Planning Application Ref: FP/123/17/T

Location: 16 Wellers Close, Felpham

Description of works: Monterey Pine to have limbs on east side over garden reduced by 2.5m to 4m

Additional photos for
16 Wellers Close BE
FP/123/17/T

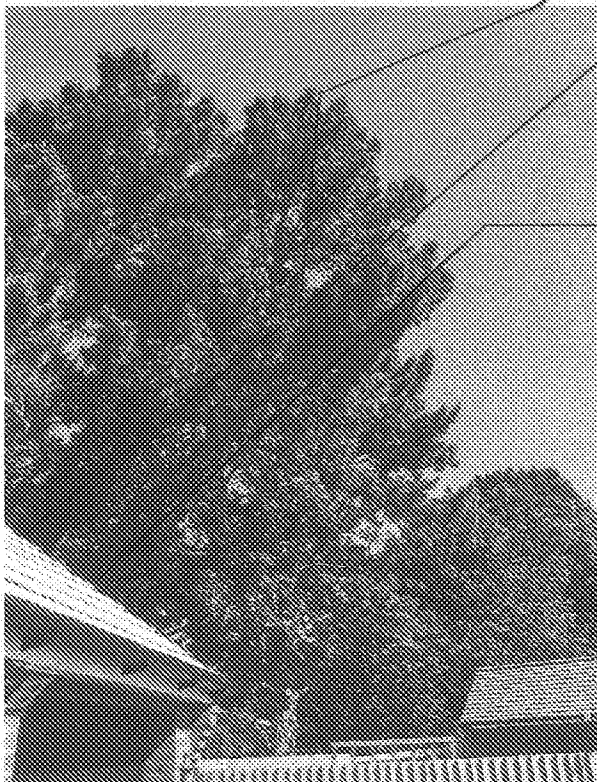
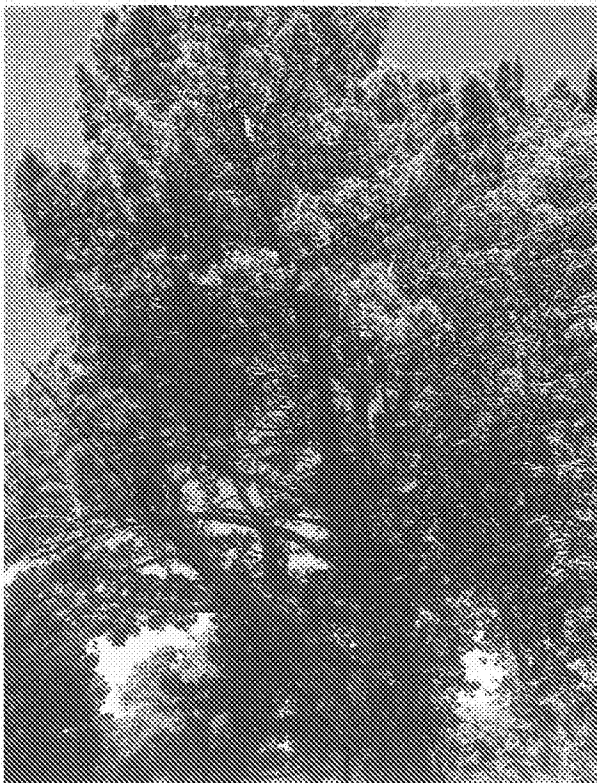
- A mature tree of significant proportions but development has been permitted too close to the tree and the inevitable 'pressure to prune' has arisen.
- It causes some shading in the late afternoon/evening and has heavy branch overhang of the garden with safety concerns ensuing.
- It is understood that the tree may be in the ownership of the developer of this land so written permission will need to be obtained before any works can be undertaken.

- The proposal to reduce the length of several overhanging boughs by between 2.5m and 4m is reasonable to address the problems and inconvenience being suffered and will leave the tree in a safe condition.

- I recommend **APPROVAL** of this application subject to permission being obtained from the tree owner and also applying the following conditions: –

- Where whole branches are to be removed and final cuts made close to the trunk or branch union they are to be made as shown in Figure 2 of BS3998:2010
- Where branches are to be shortened back the final cuts are to be made at the correct angle shown in BS3998:2010 and adjacent to a live bud or lateral.
